To Will Hopcroft
From Joanne McKay – Growth Lancashire
Subject Conservation Comments
Date 20 March 2023

Ref: 3/2022/1159

Proposal: **Listed Building Consent for external repairs to right-hand (NE) gable comprising lining stone copings, replacement of chimney flashing, re-rendering, re-pointing and redecoration, internal re-plastering, redecoration and installation of extraction fan and ventilation, gutter and downpipe repairs.**

Site Address: **4 Alms Houses, Stydd Lane, Ribchester PR3 3YQ**

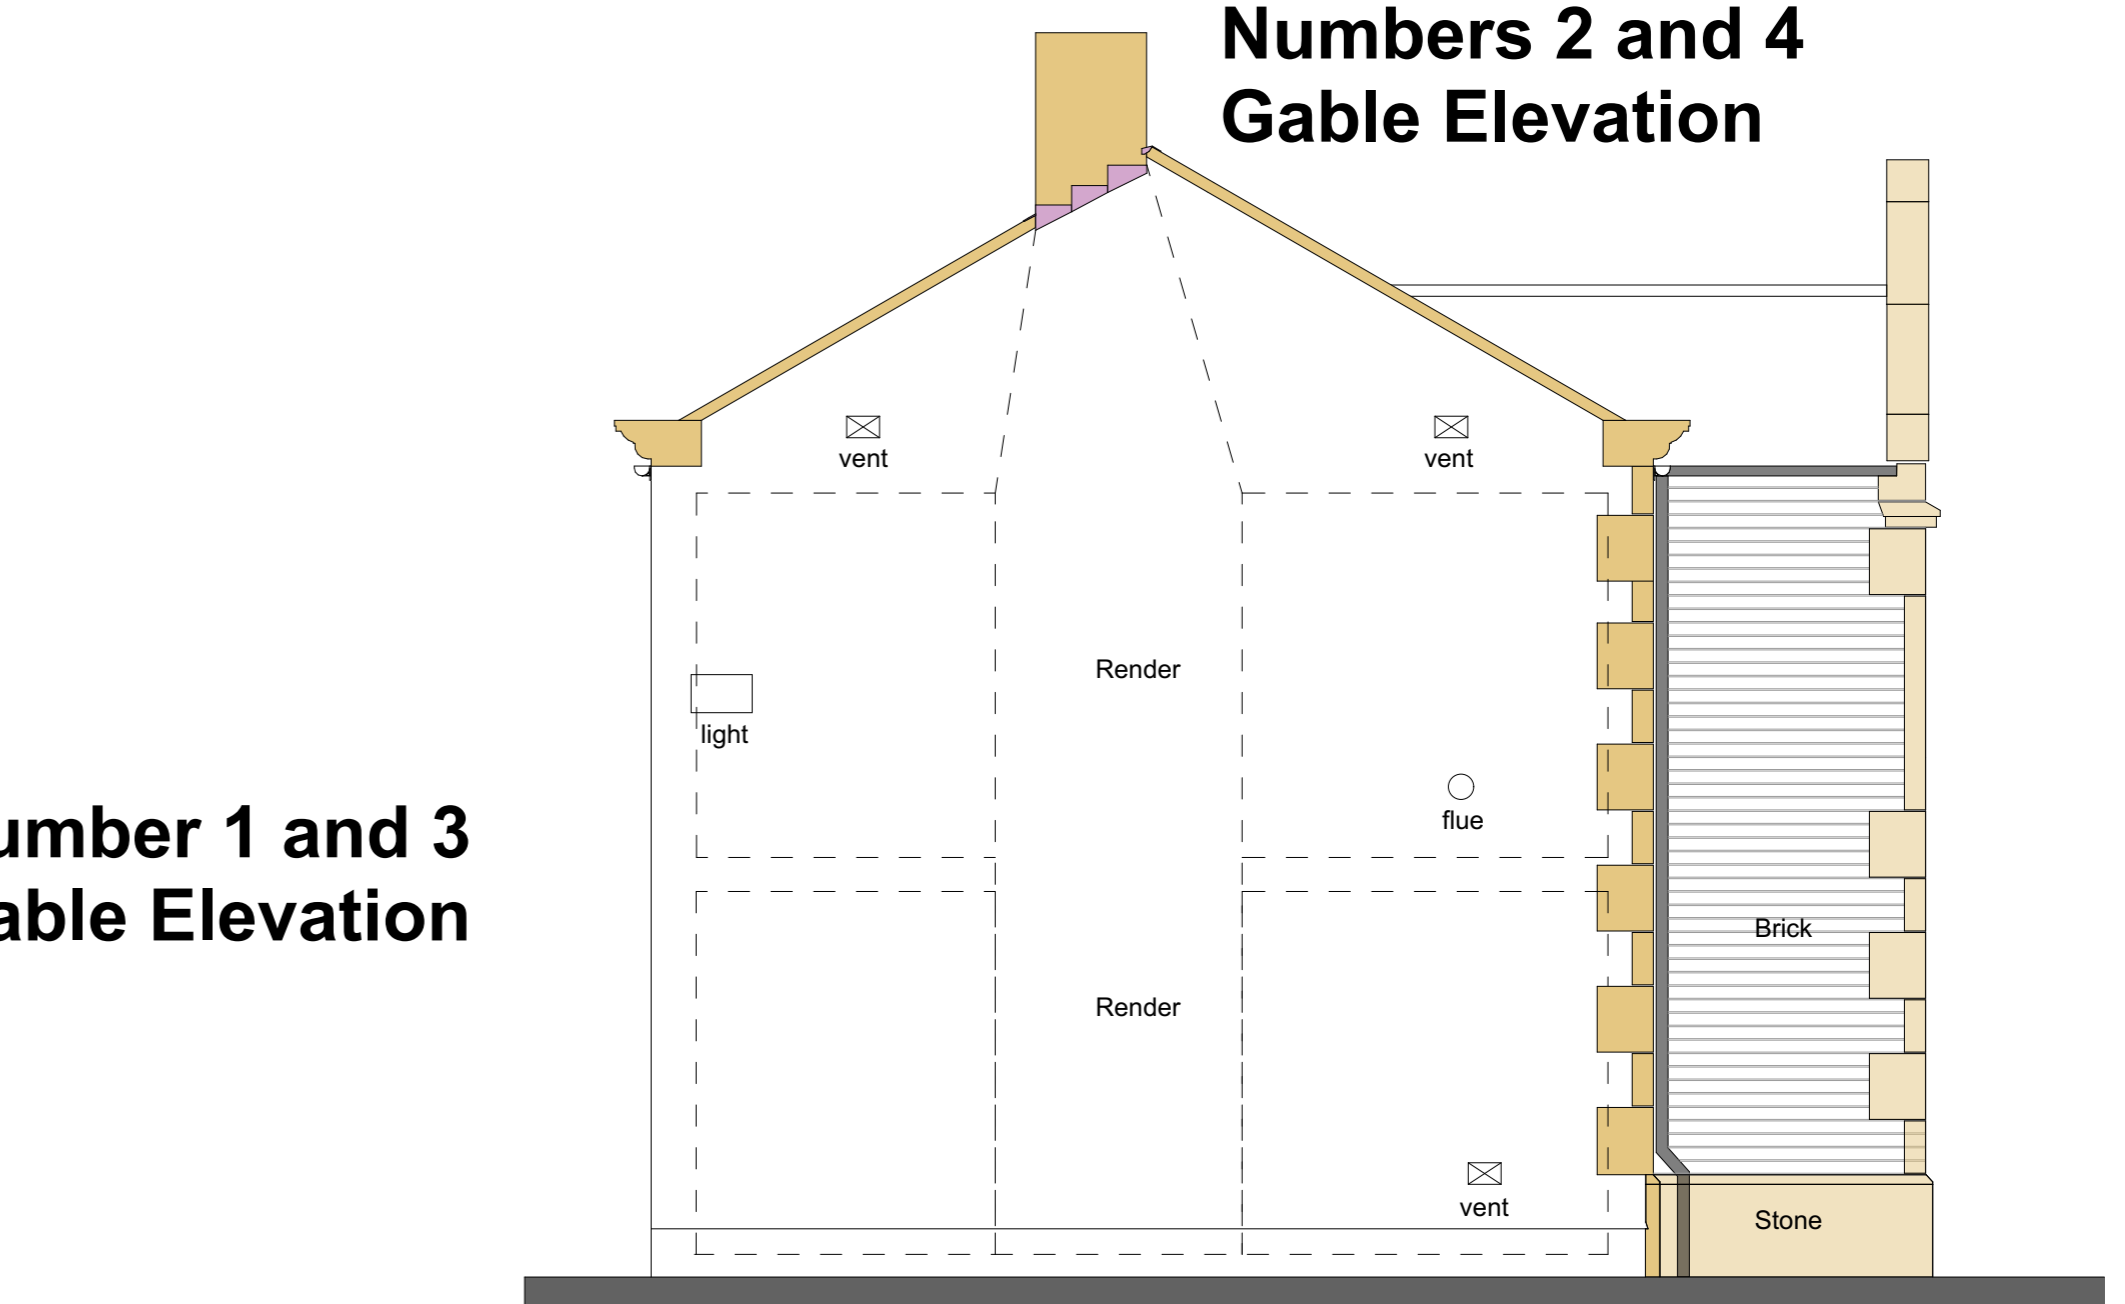
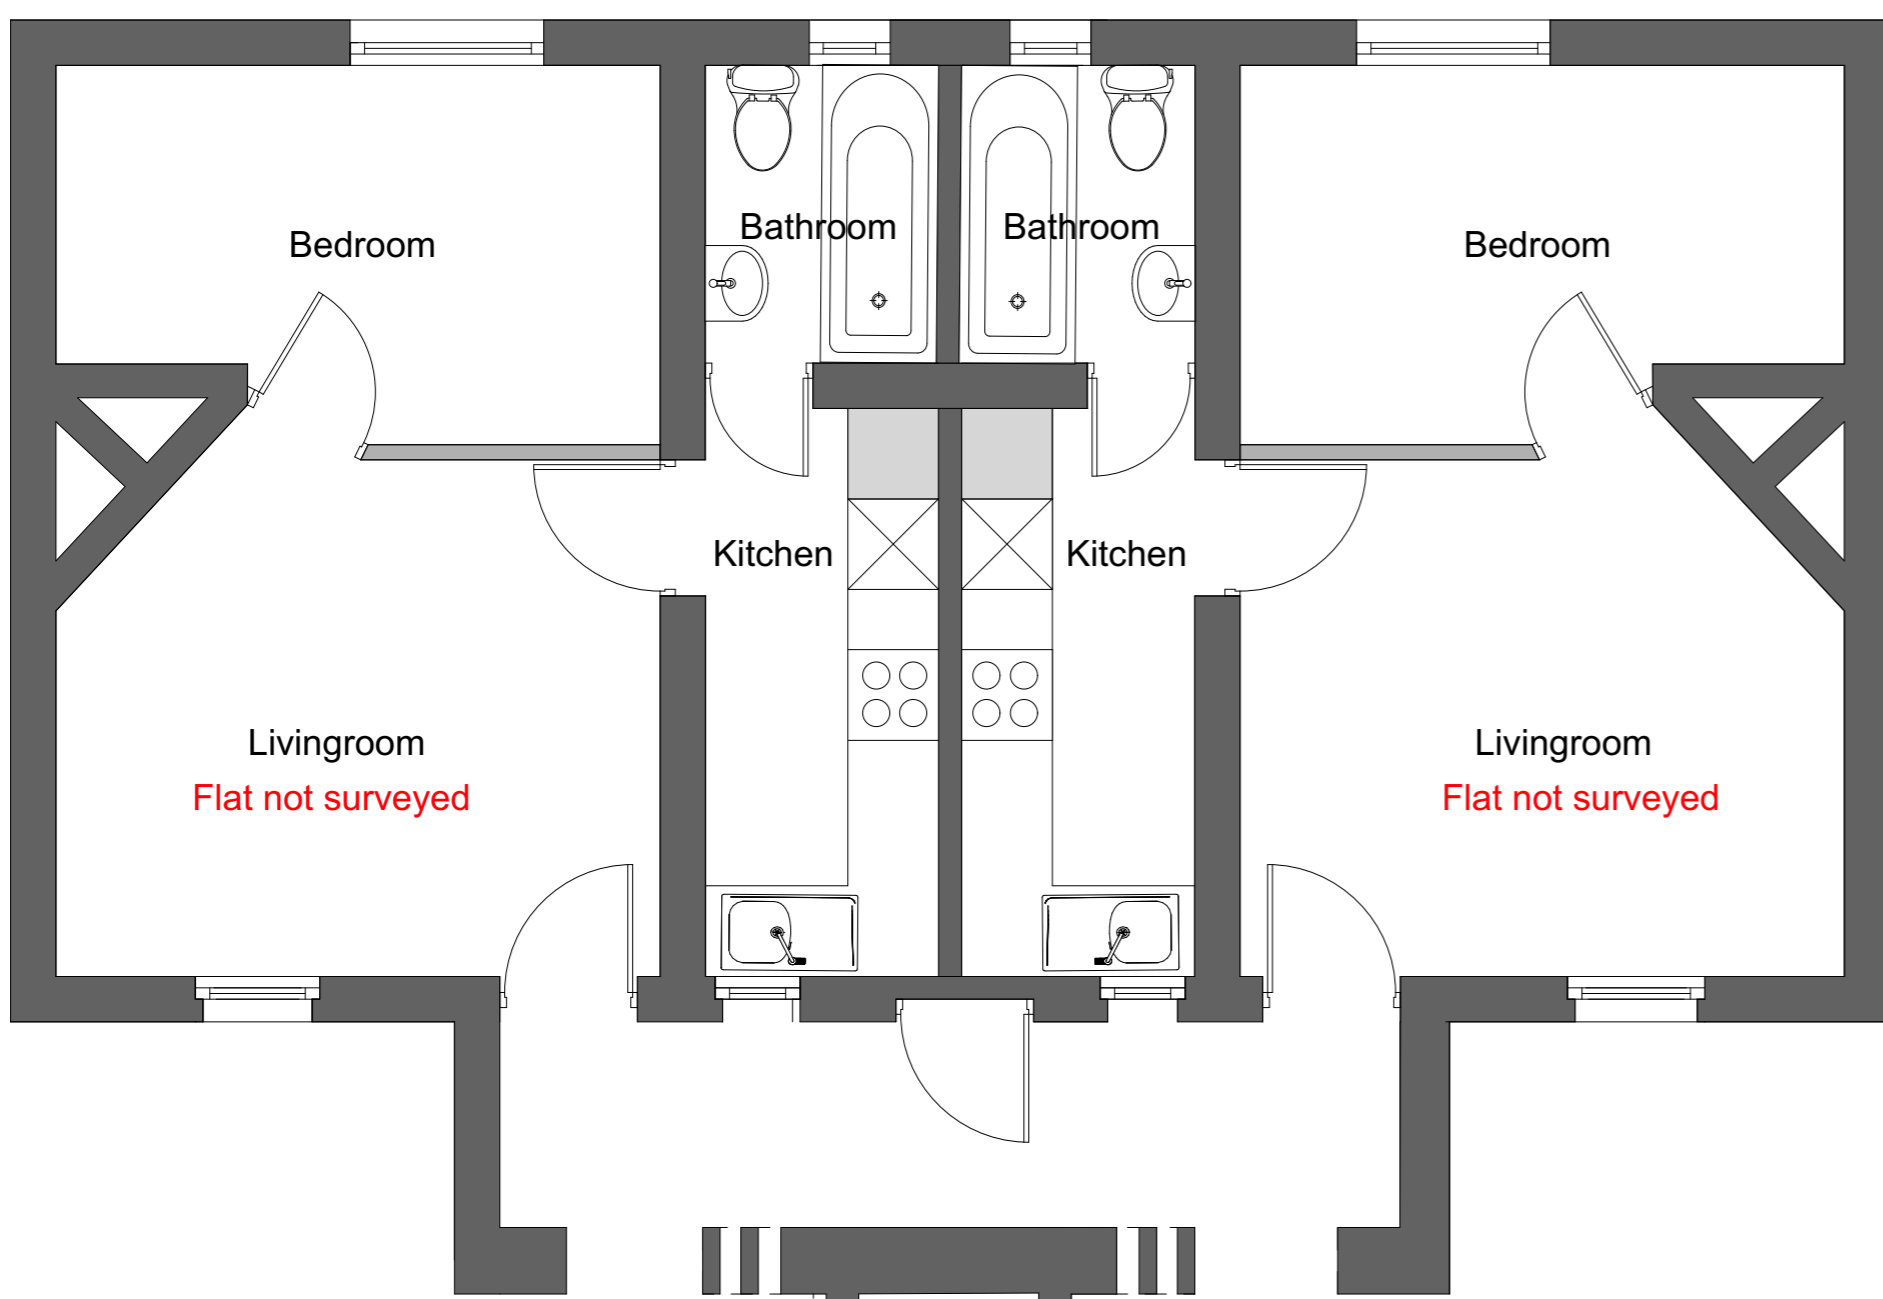
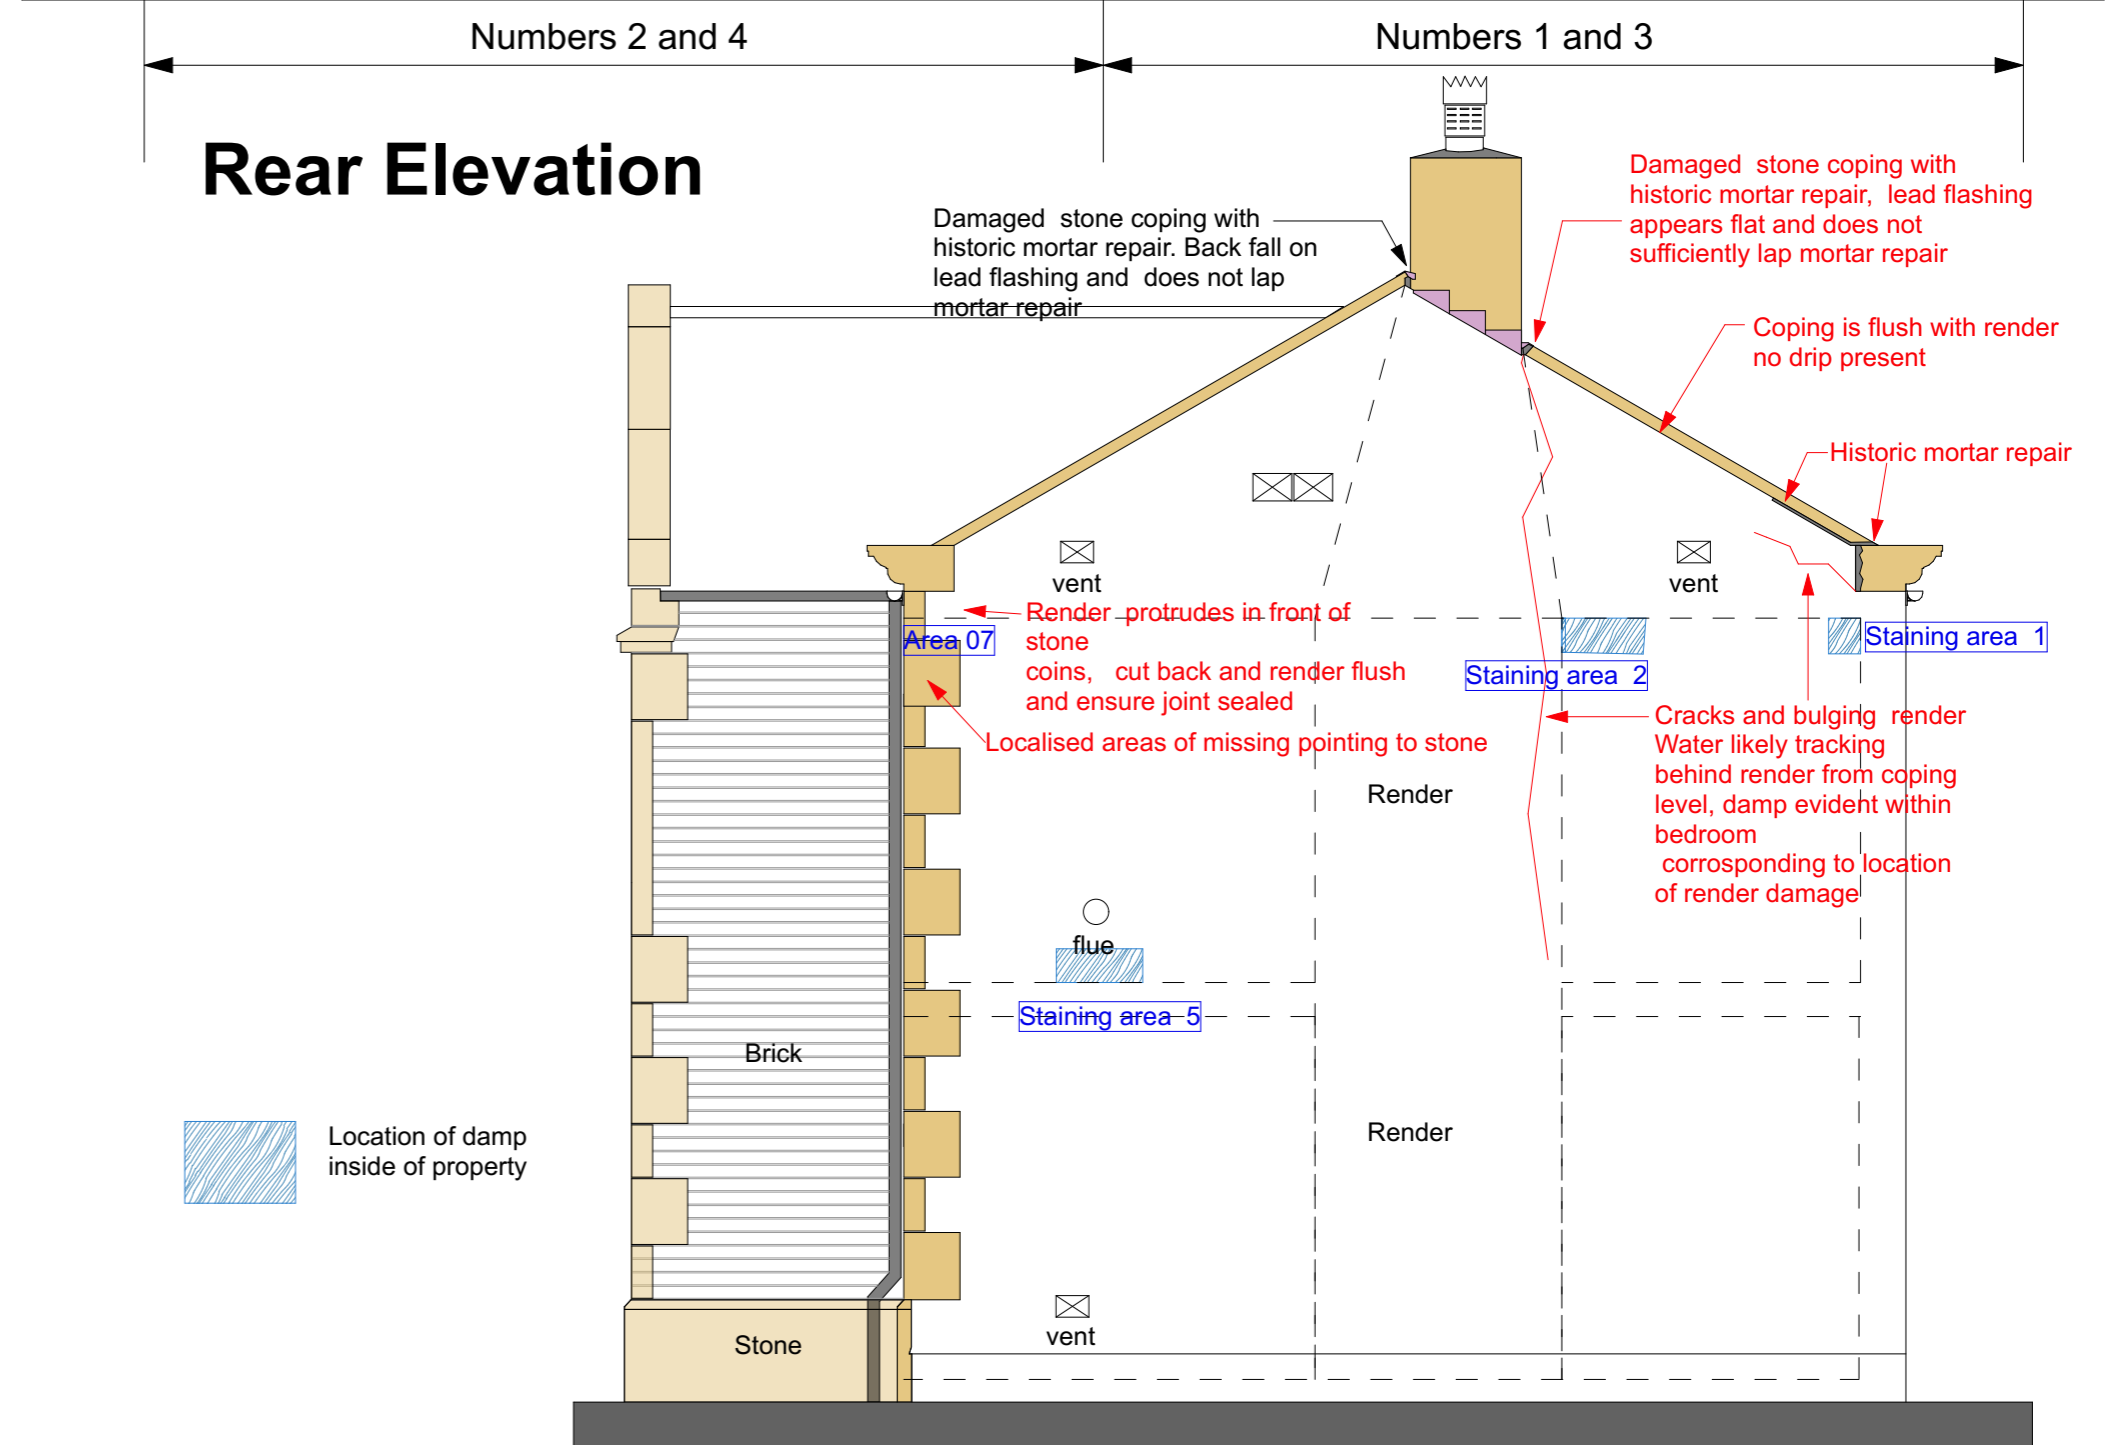
The proposed works to remove the copings, lay new and increased lead flashings and replace existing copings; in my view is appropriate and beneficial work, which should have no impact on the character of the LB. However, the

submission provides no details as to how the copings are to be removed, marked and protected until they are relaid. I would prefer that the removal, marking and storage details are provided prior to the planning decision being made. However, these details can also be secured via a suitably worded (methodology) condition.

In relation to the proposed stone repair works, which involve the repair of the outermost stone edge of the copings. The system proposed is a mortar restoration system. On reviewing the D & A Statement against the proposed plans, it is unclear if the stone repair works relate to other areas of the property. Furthermore, on looking at the variety of specifications for the various preparation applications it is unclear if the proposed products (or some of) are concrete based products. As such, I would recommend further clarification of the individual preparation and finishing products is required.

Additionally, the submission documents do not provide any justification for the mortar repair approach or why this method has been selected instead of other more appropriate conservation techniques, including stone repair (i.e. pinning or indent repairs) or replacing the stone copings with like for like materials. There is no information (Condition survey) on the level of damage to the stone copings, or why they need repairs. This information would allow for a full assessment of the proposed works, materials and appropriateness of the proposed repairs. Whilst, I am not opposed in principle to this type of restoration product being used the preferred option would likely be the use of stone repairs or the replacement of badly damaged stone copings with like for like materials.

As indicated above further information and clarification is required with regards the stone repair and/or restoration works proposed to the existing stone copings. I do not feel that this part of the proposals are adequately justified at present. I would like to see the background reports that specifies this type of restoration work/technique be used. It may be that a sample of the mortar restoration is provided by the contractor on a sample coping stone and made available for inspection, prior to a decision being made.

Alternatively if the LPA is minded to approve the application then I would suggest that a suitable worded Condition be used requiring a sample of the stone restoration technique to be provided and agreed prior to commencement on site.
